Application No: FG/52/22/HH
Site Address: 6 Beehive Lane Ferring BN12 5NL
Description of works: Erection of two storey front extension with front canopy, single storey side and rear extension and extension of loft to habitable use including the installation of 1 x side dormer.

Thank you for your internet representation made on 12th April 2022 which has been recorded as an objection with the comments as follows:

Drawing
Proposed Elevations

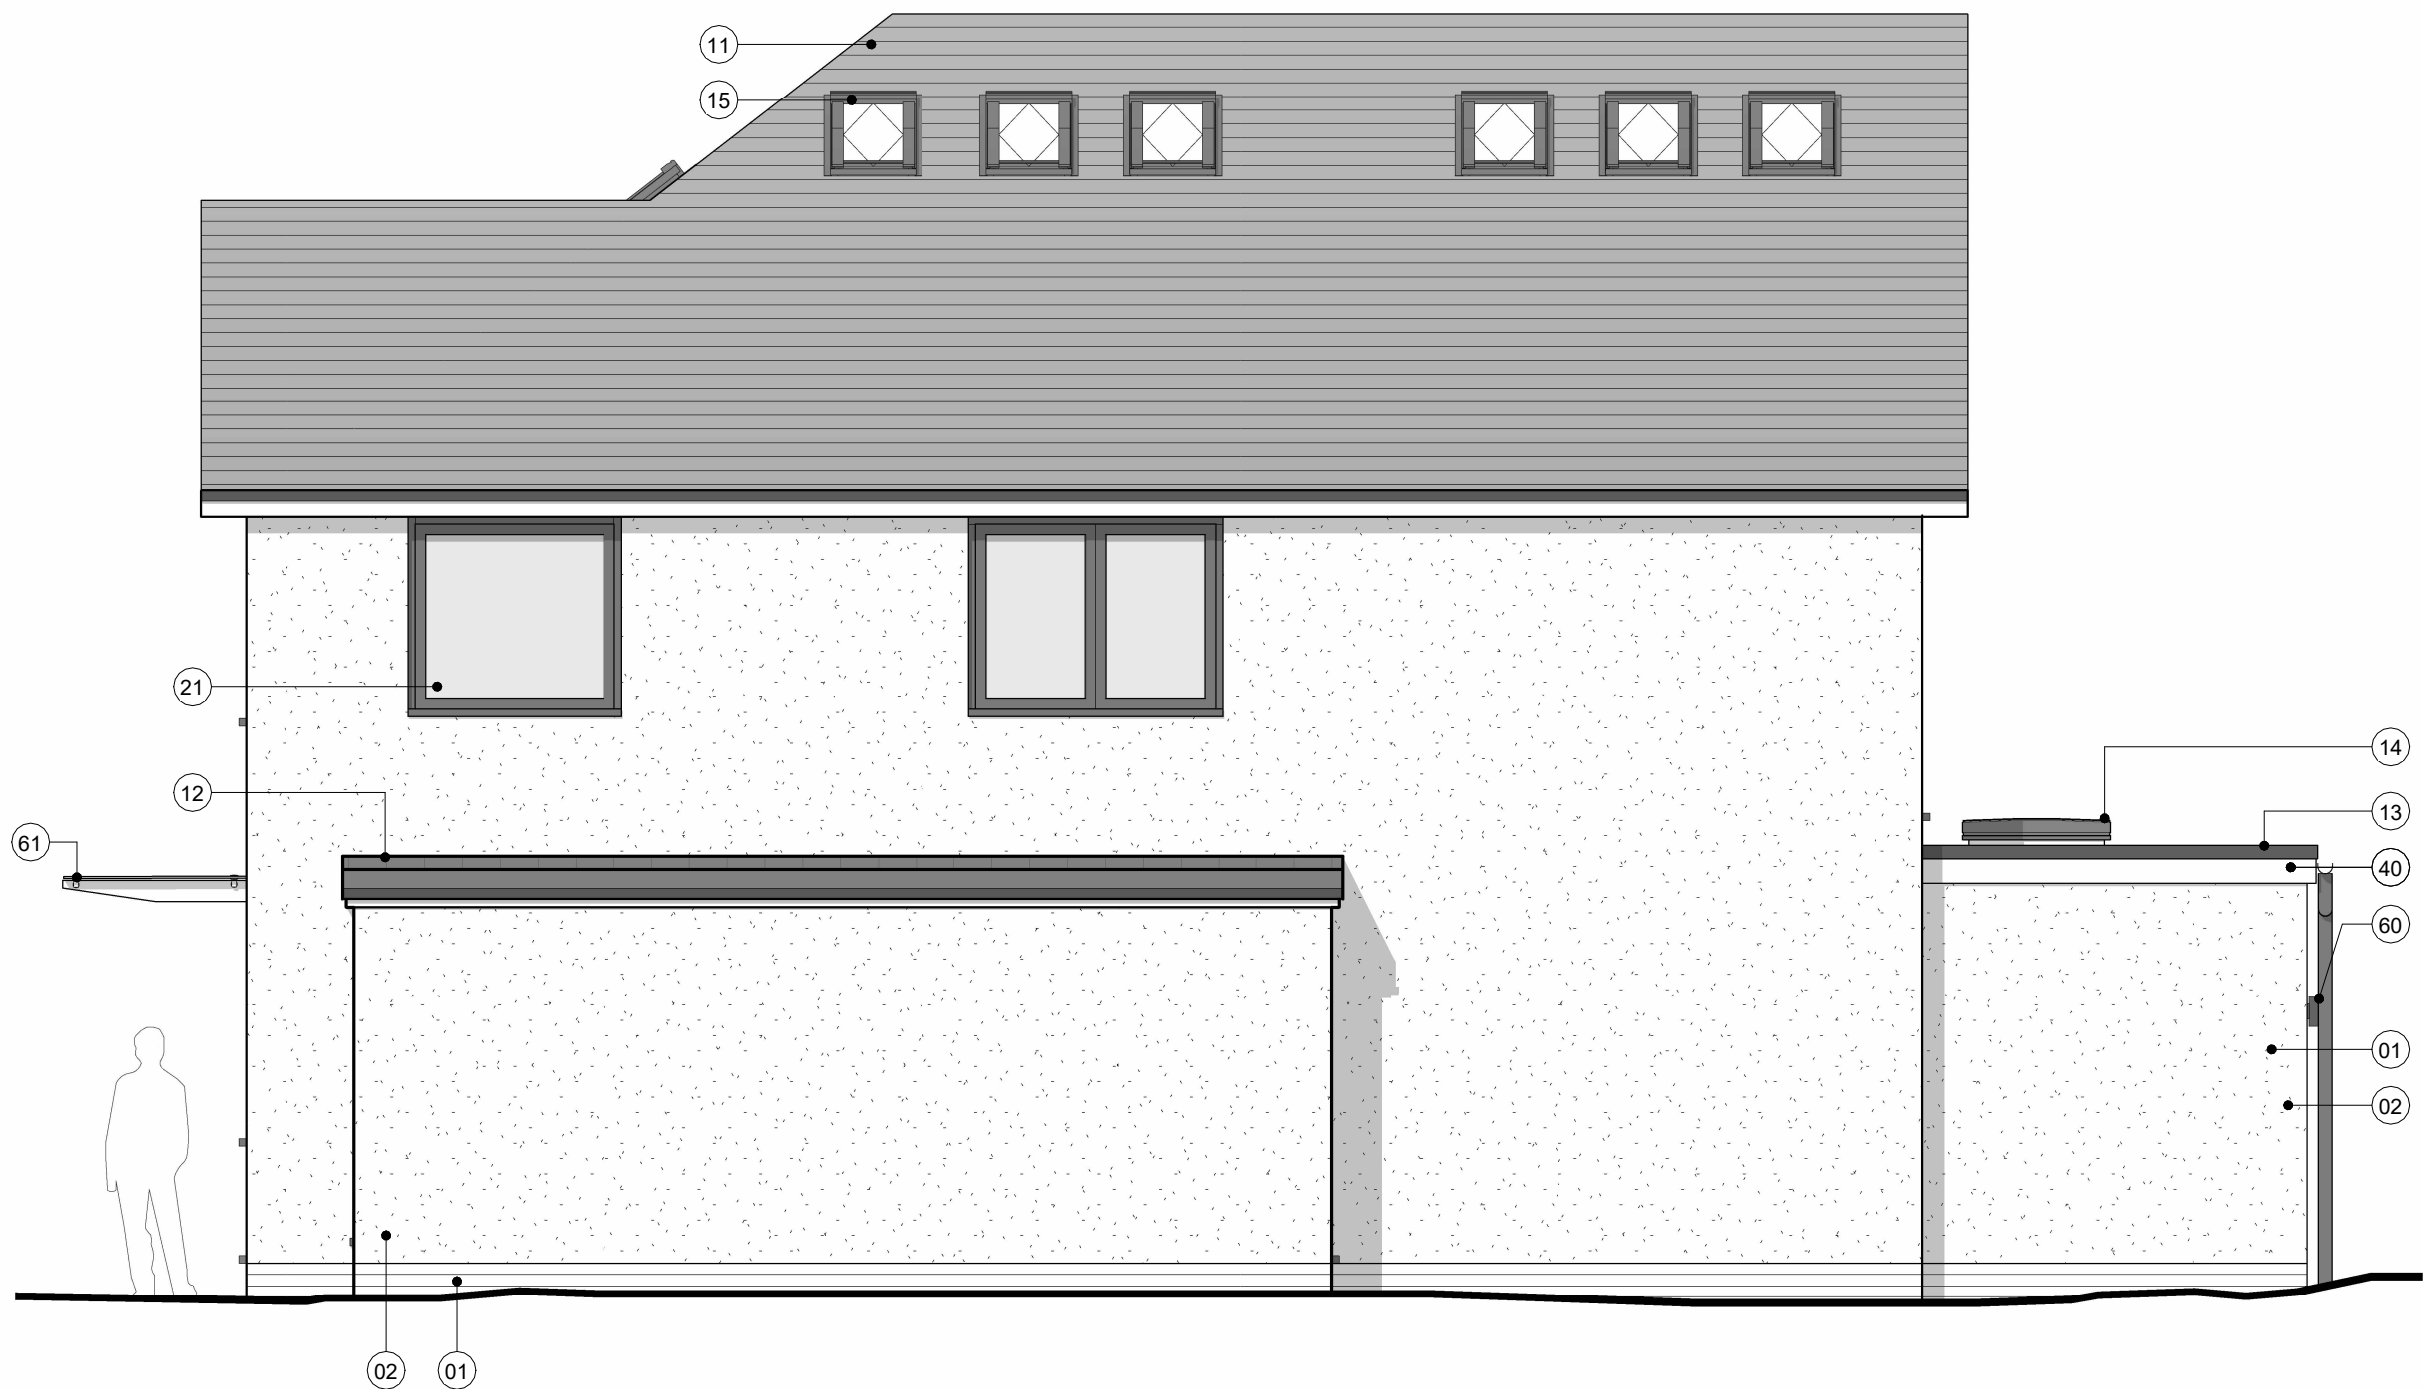
The proposed dormer roof is poorly articulated and will create an overbearing impact on the adjacent property (No8) which is a single storey bungalow and will look unsatisfactory when viewed from Beehive Lane. We believe it is perfectly possible to design a better alteration to the existing roof which reflects the quality of the other properties on Beehive Lane and that can complement the streetscene. I would also question the additional windows which are not obscure on the side of the property which will impact on our privacy.
